REF: 20/03660/REM

Location: Stone Pits Hempton Road Deddington OX15 0QH

17 February 2021

DRAWING TITLE:  
PLOT 19-21  
ELEVATIONS AS PROPOSED

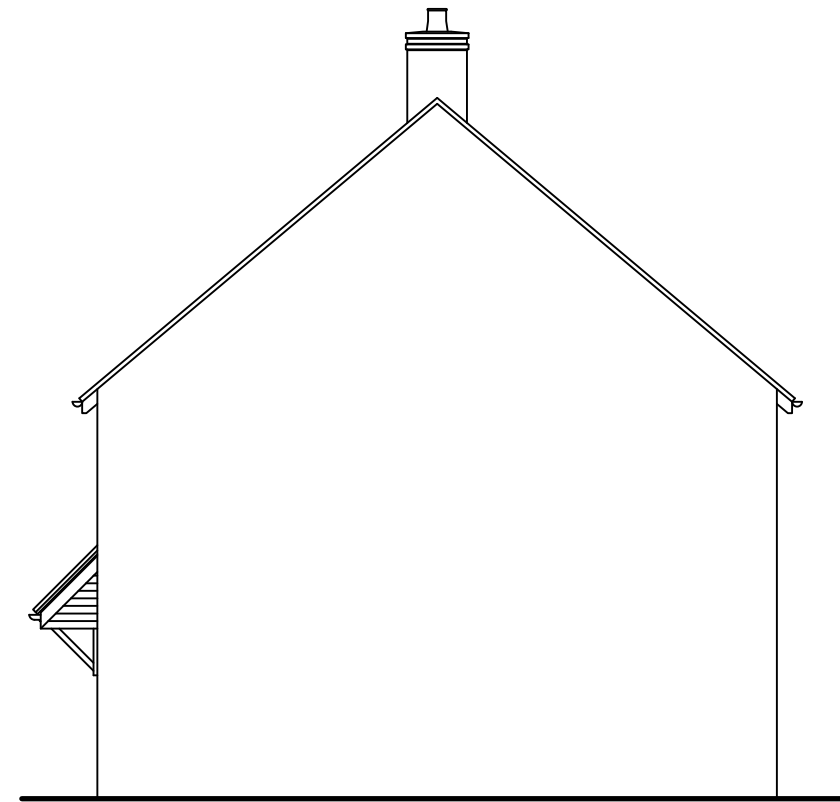
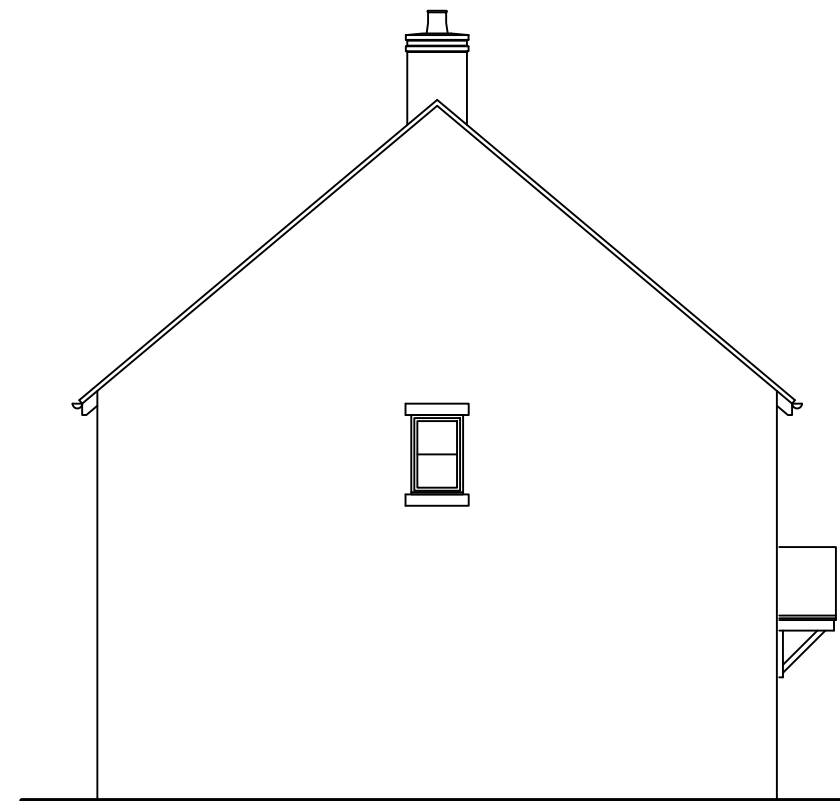
The rear access for plots 15-21 exposes the vulnerable rear and side boundaries of plots 14-21 if not robustly secured. These boundaries are the point of entry for most residential burglaries, and must be sufficiently secured. The rear access route for all of these plots also terminates between two unallocated parking spaces, which if insufficient space is provided could result in accidental damage to cars and subsequent neighbourhood disputes.

I ask that the rear access route is secured as close as possible to front fascia of plot 19. The boundary treatment should be 1.8m close boarded fence. The route should be secured with a robust gate of the same height, with self-closing hinges to prevent it being left visibly insecure, and should be fitted with a key lock operational from either side. Sufficient space should be provided around the access point to allow safe manoeuvrability of garden equipment past parked vehicles, but should not run between parking spaces. The size of the rear access should be reduced – Plot 21 should access their rear garden from the front fascia of their plot, and the communal rear access should terminate at plot 20. Plot 17/18 should be able to access their garden through their own boundary at the front of the building.

LANDSCAPE MASTERPLAN
HARD AND SOFT LANDSCAPE

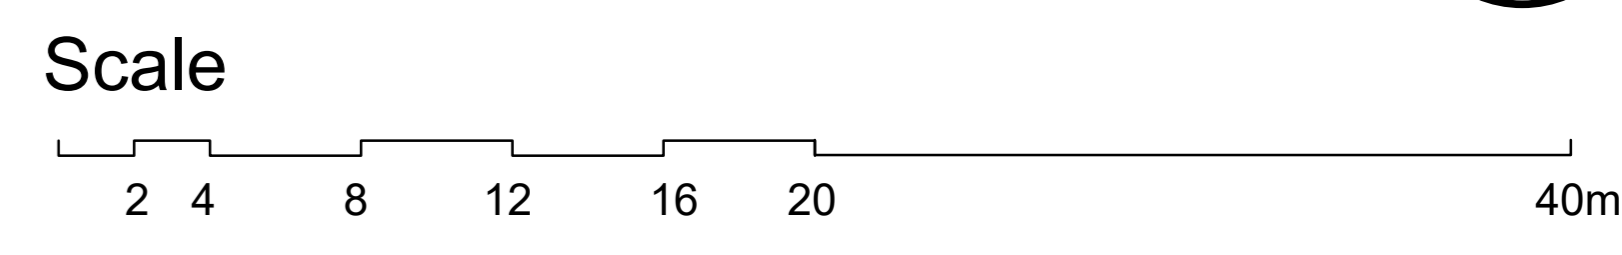
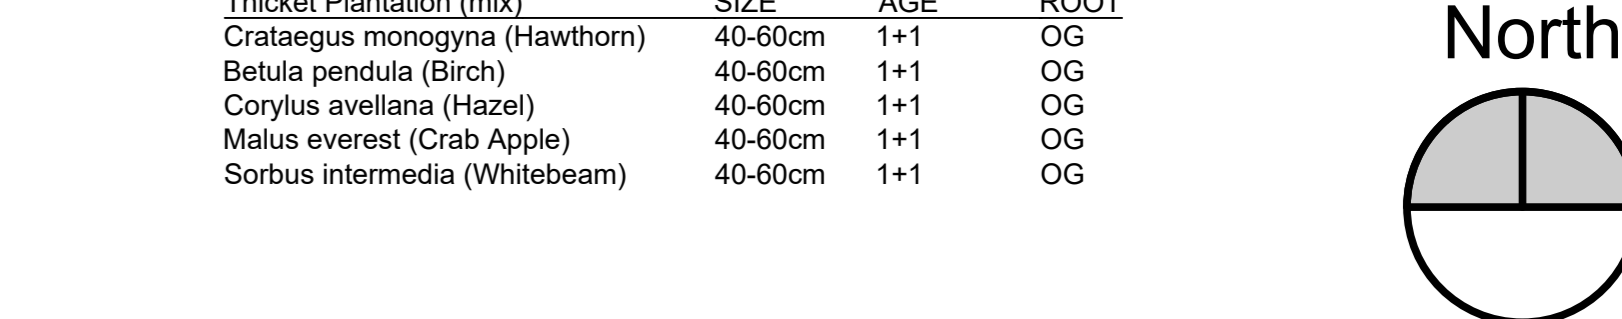
The proposed parking barn provides offenders with access to parked vehicles in an enclosed space, limiting surveillance opportunities, particularly at night. The potential risk of crime and anti-social behaviour occurring in terms of the proposed parking is exacerbated with the apparent unallocated parking. Unallocated parking makes it difficult for future residents to identify and challenge the presence of an offender or suspicious activity and is inappropriate in a private parking court.

I am unable to locate details of boundary treatments, without which I am unable to assess the level of surveillance provided from the private realm to the public realm and vice versa.

The pedestrian link to the north of the development creates an excessive level of permeability. It introduces a level of anonymity associated with its public use and should be pushed away from the private areas of the development. Whilst clear and direct routes are important they should not undermine the defensible space of neighbourhoods. Furthermore, I cannot identify the necessity or intended legitimate use of this route, however it provides an opportunity for offenders to enter and leave the development with surveillance obscured by the parking barn.

Surveillance to this area needs to be increased. It would be more appropriate to enclose the communal parking with low level hedging, enabling clear unhindered sight lines from across the development to parked vehicles whilst providing them defensible space. Spaces should be allocated, and where visitor spaces are required these should be clearly identified, and overlooked by active rooms from surrounding dwellings.

I ask that a boundary treatment plan is submitted to the LPA for scrutiny prior to permission being granted. Robust boundary treatments must be provided to adequately protect private gardens and vulnerable rear and side elevations, the point of entry for the majority of burglaries. It should not be assumed that all offenders are external to a development and appropriate boundary treatments will help to prevent neighbourhood disputes. Boundary treatments protecting vulnerable side and rear boundaries should be a minimum height of 1.8m. Close board fencing or similar should be used and a lower fencing of 1.5m with an additional trellis topping utilised to maximise surveillance to the public realm where appropriate.

Further clarification is required with regards to its intended use, purpose and position.
